Please ask for: Ms Iqraa Malik
Email: iqraa.malik@terraquest.co.uk
Telephone: 01212341390
Our Ref: BE/78/20/HH
Your Ref:
Date: 30th July 2020

Application for Planning Permission for Works or Extension to a Dwelling

Development: Single storey rear extension including demolition of existing conservatory and single storey side extension
Location: 111 Stroud Green Drive Bersted PO21 5SZ

Proposed Extension
Plans and Elevations
Planning

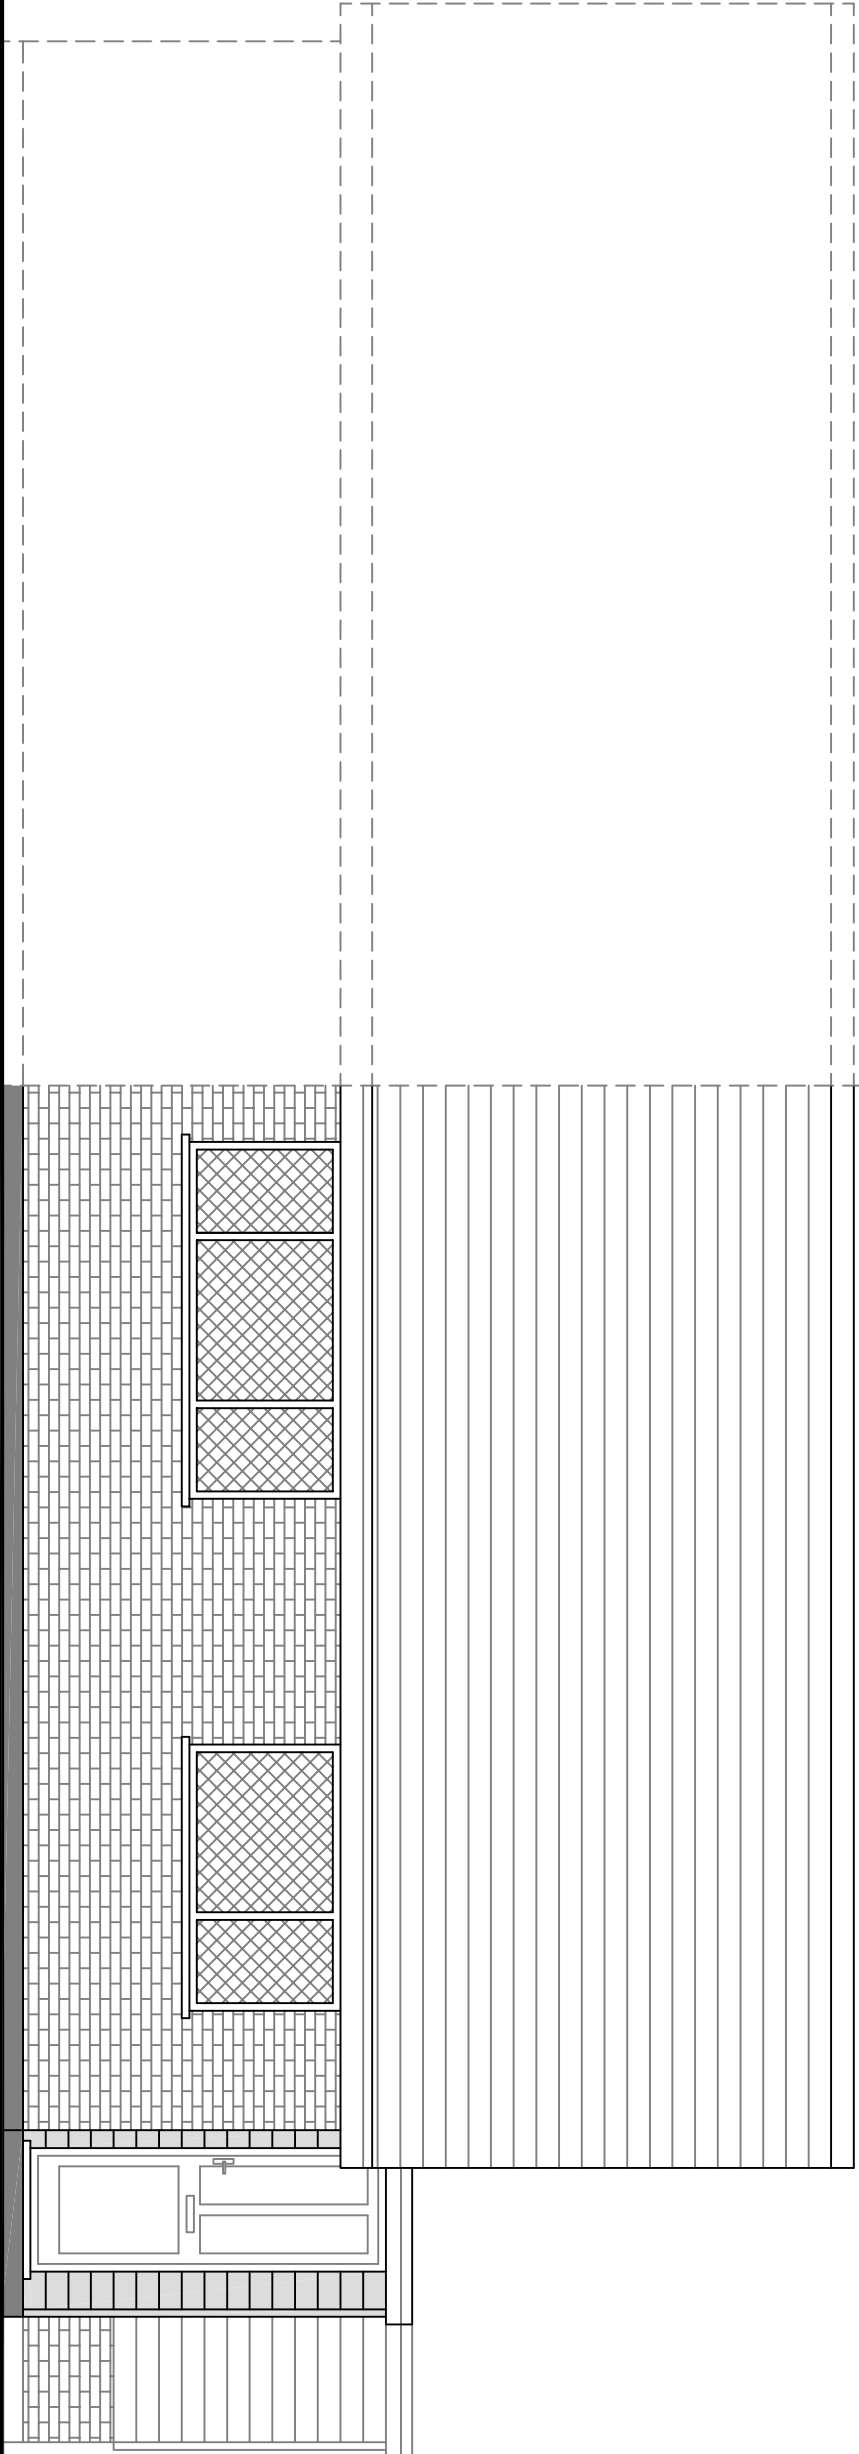
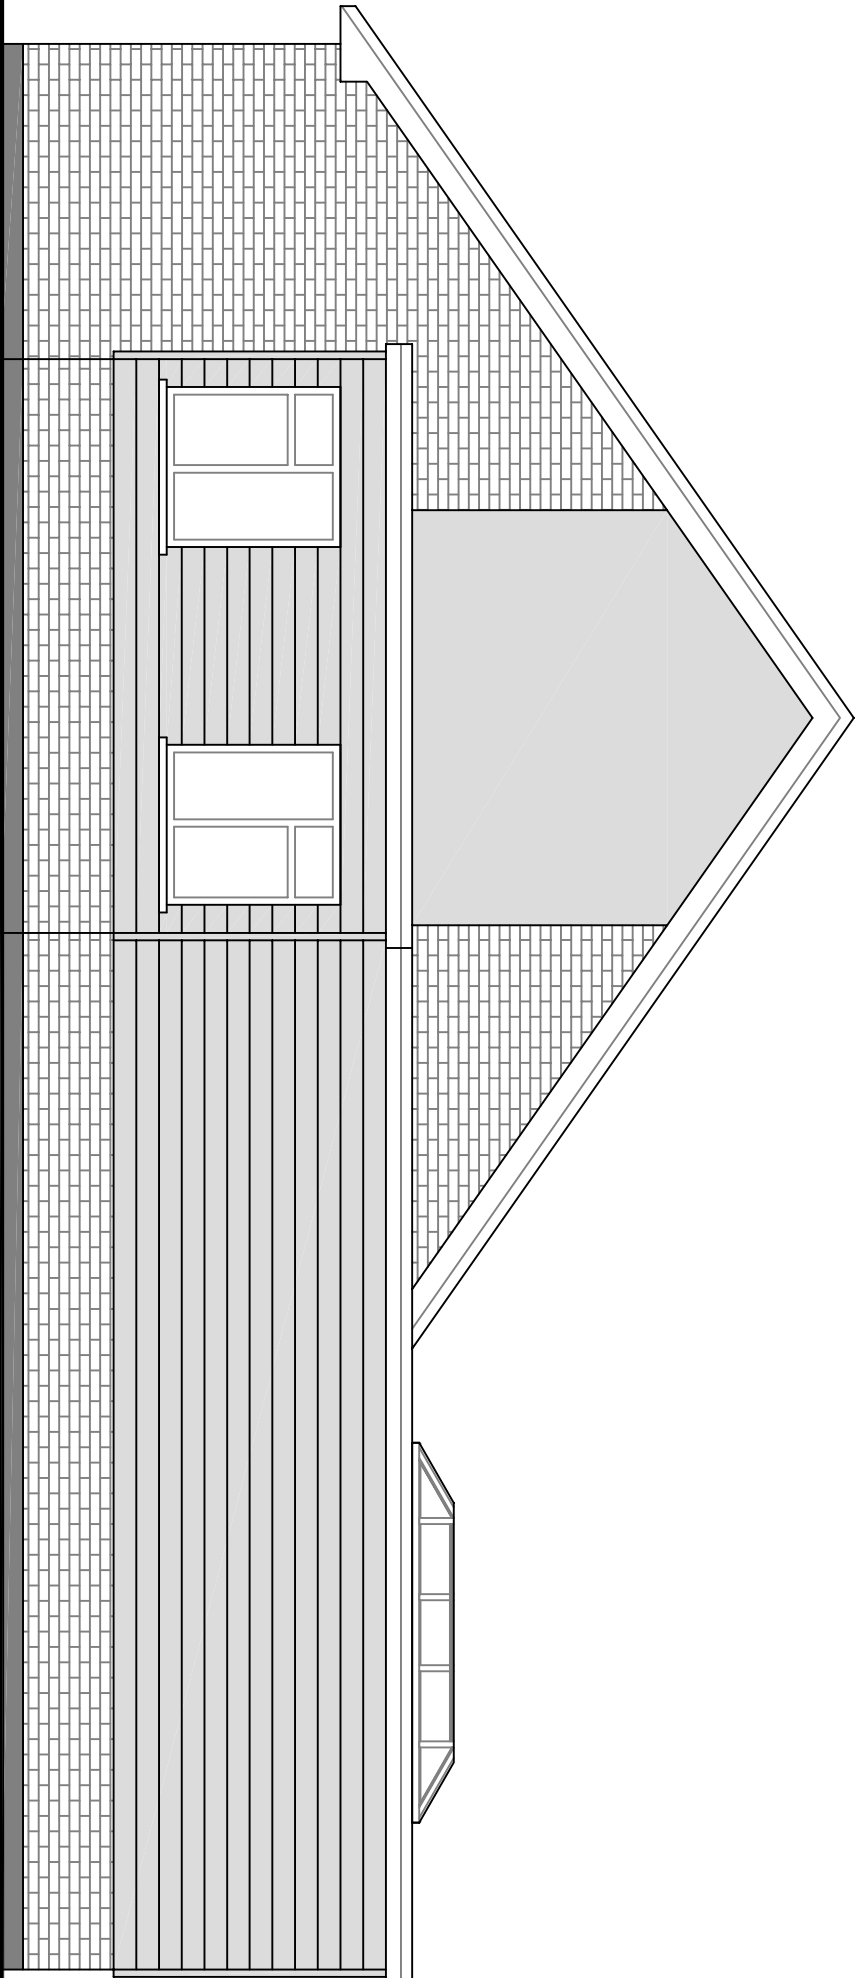
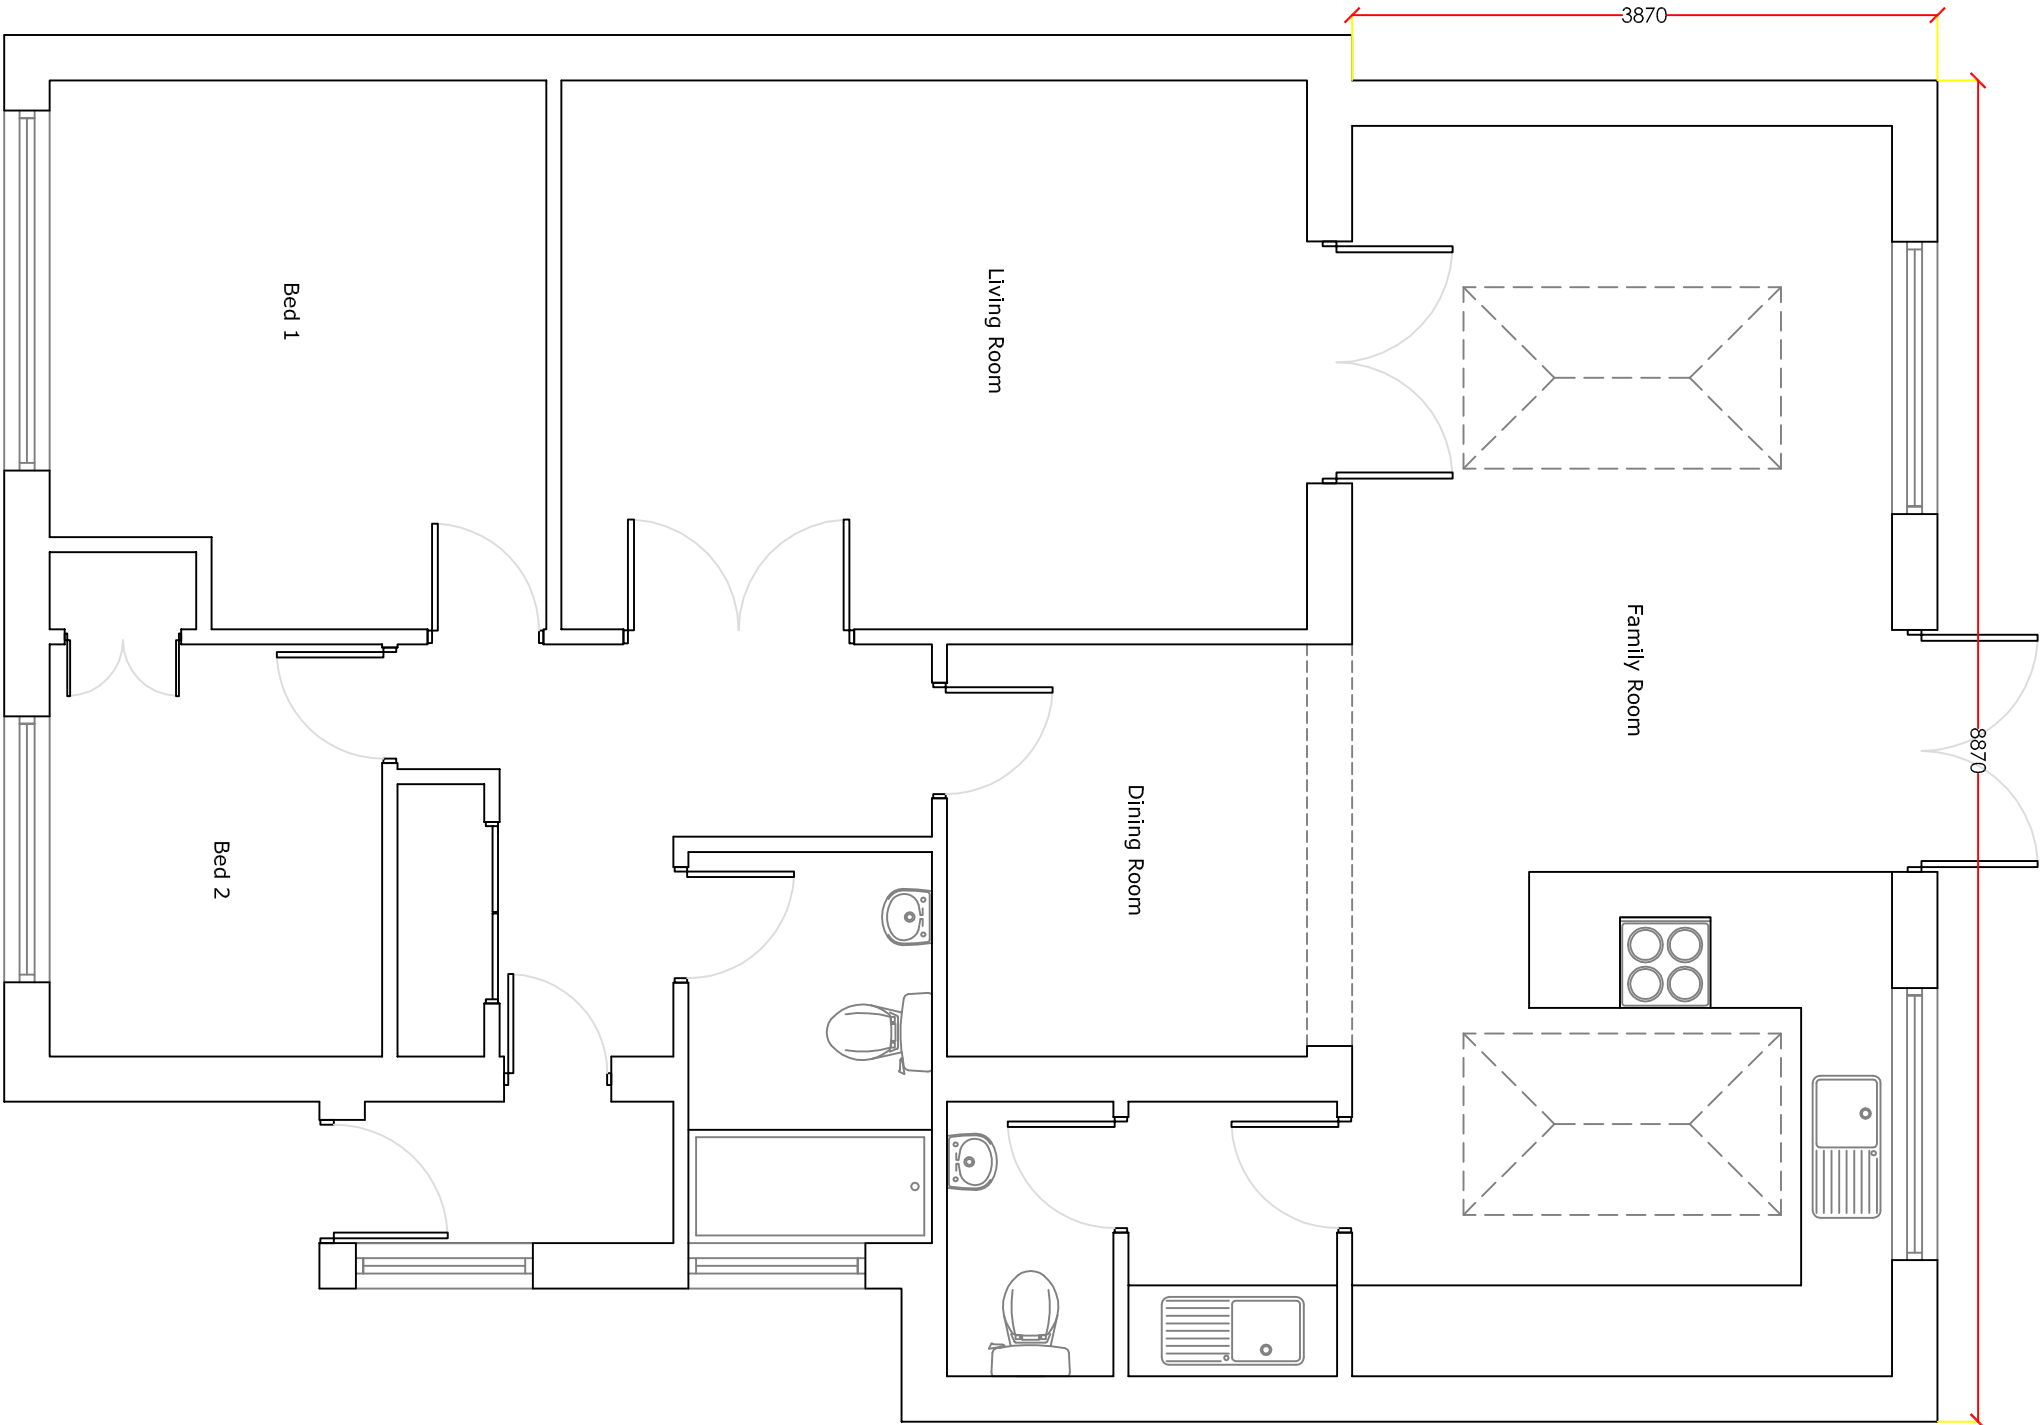
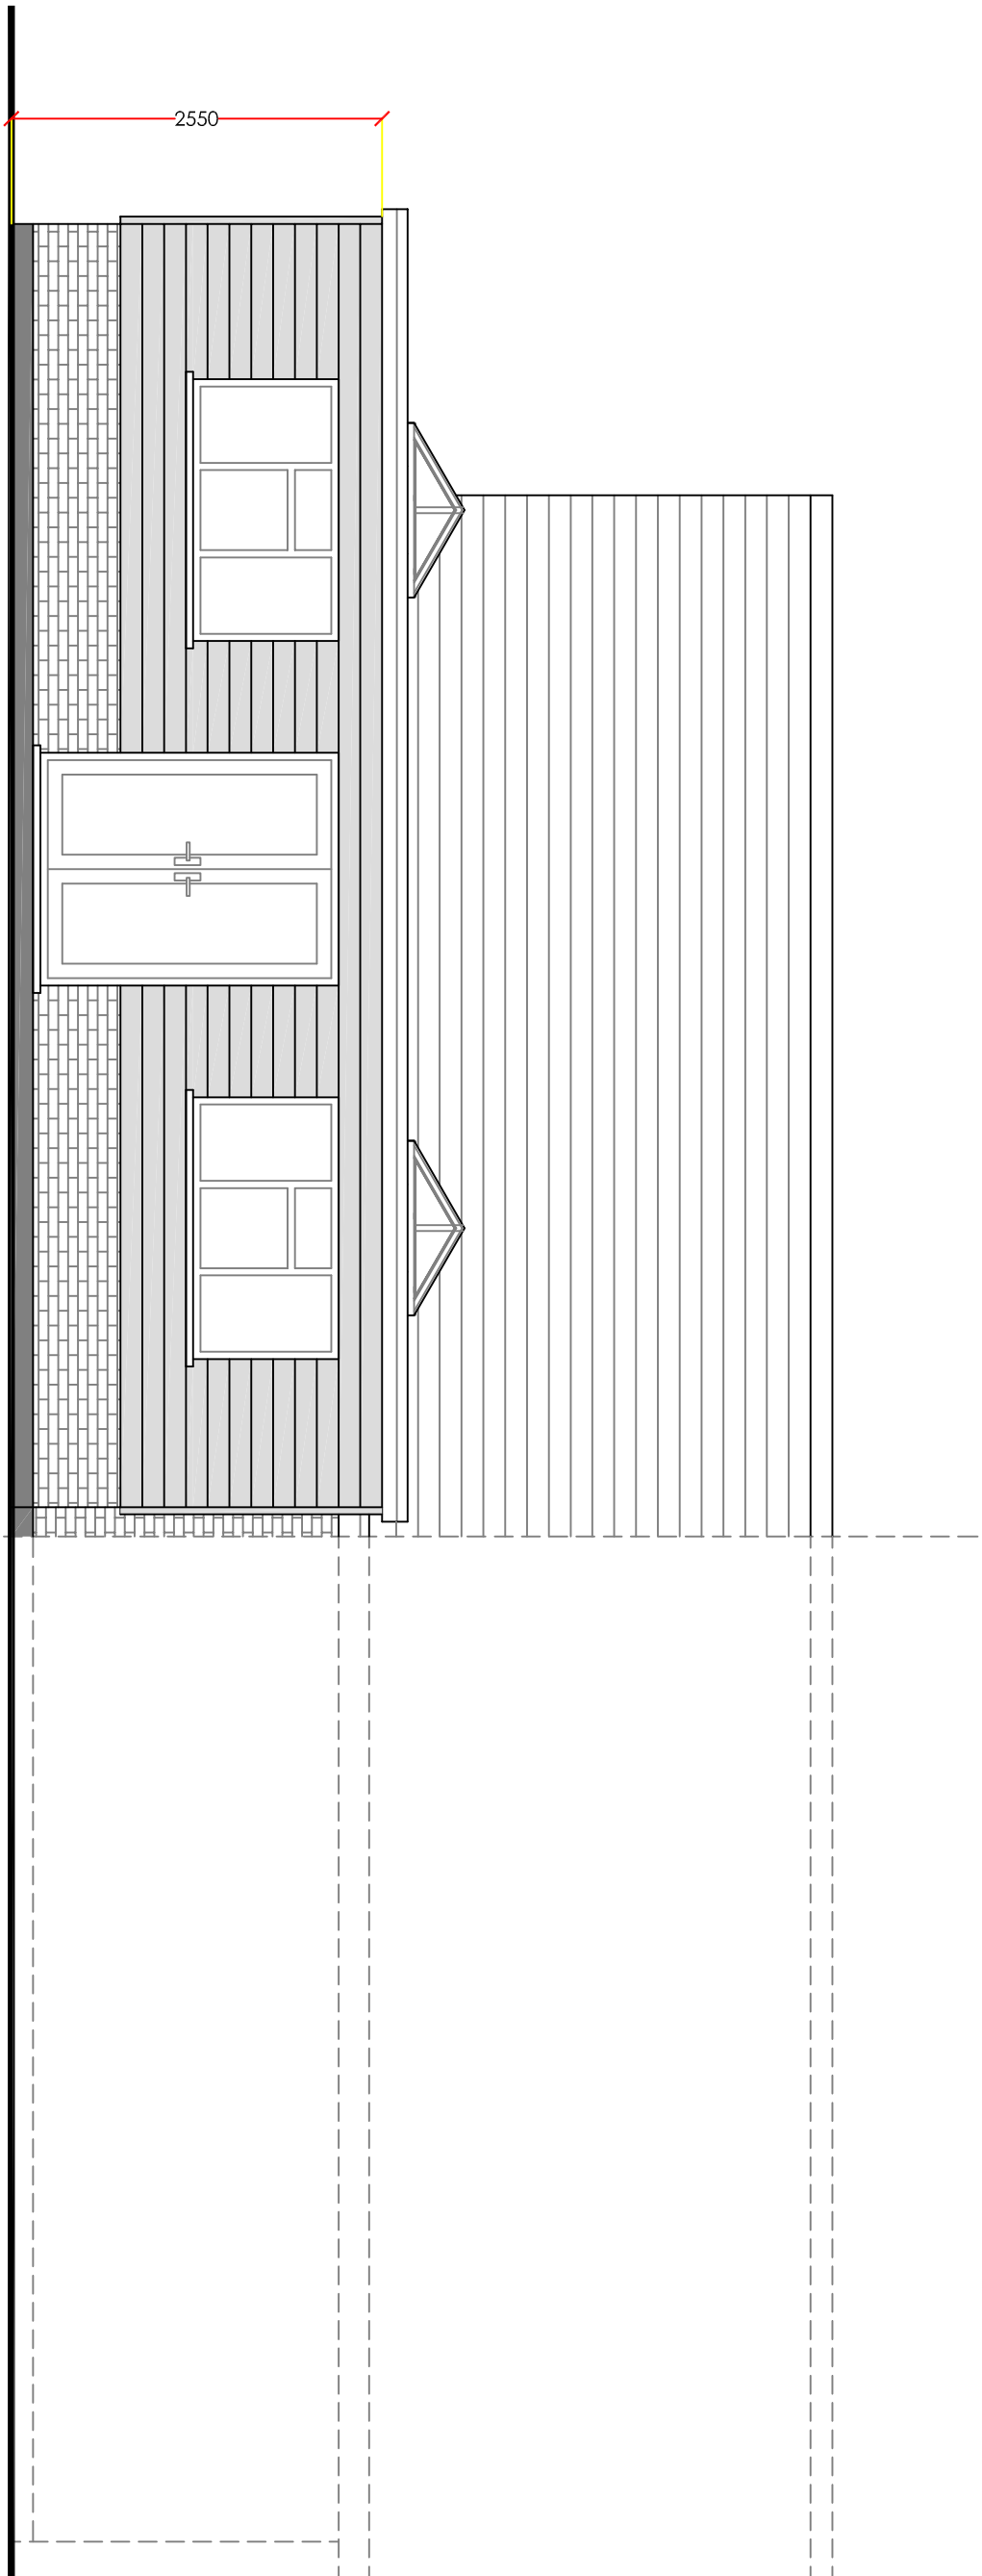
Scale Bars: You are required to have scale bars on all plans. Please amend

Other Side Elevation: Please provide the other side elevation for this application.

Proposed Extension Plans and Elevations Planning
Date
July 2020
Scale
1:200 1:1250

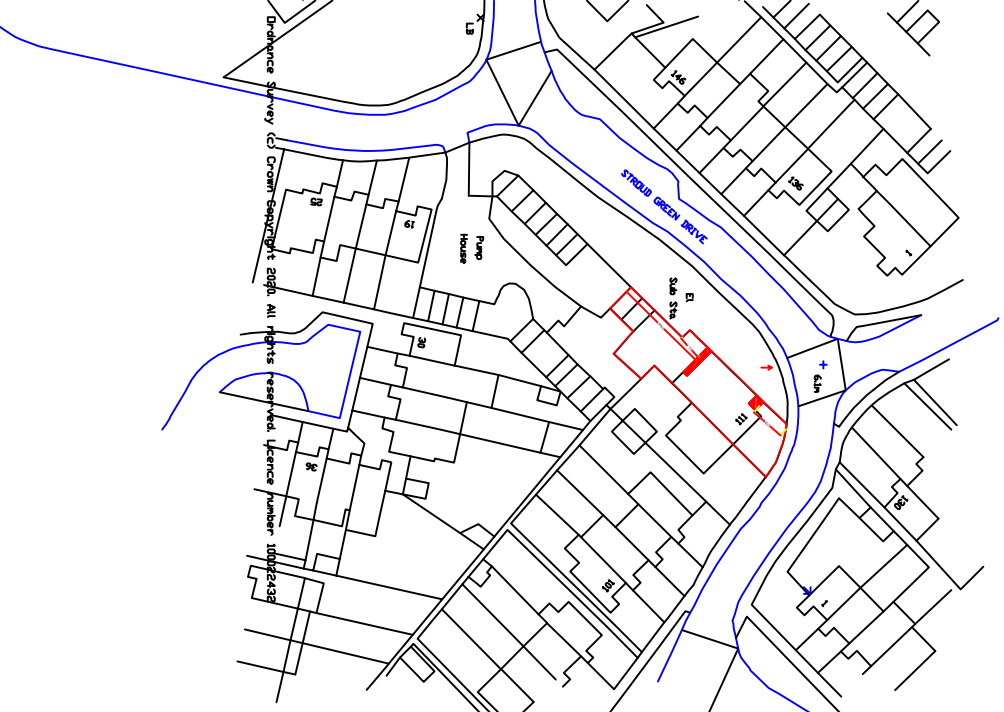
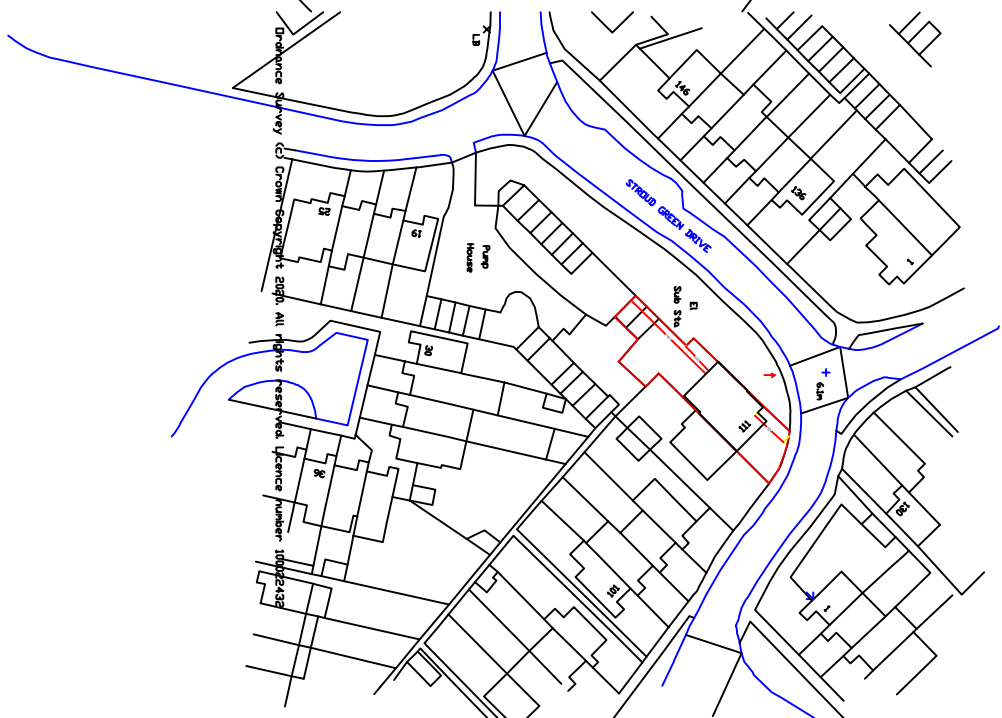
Dimensions: You are required to include dimensions from the proposed extension to all site boundaries.
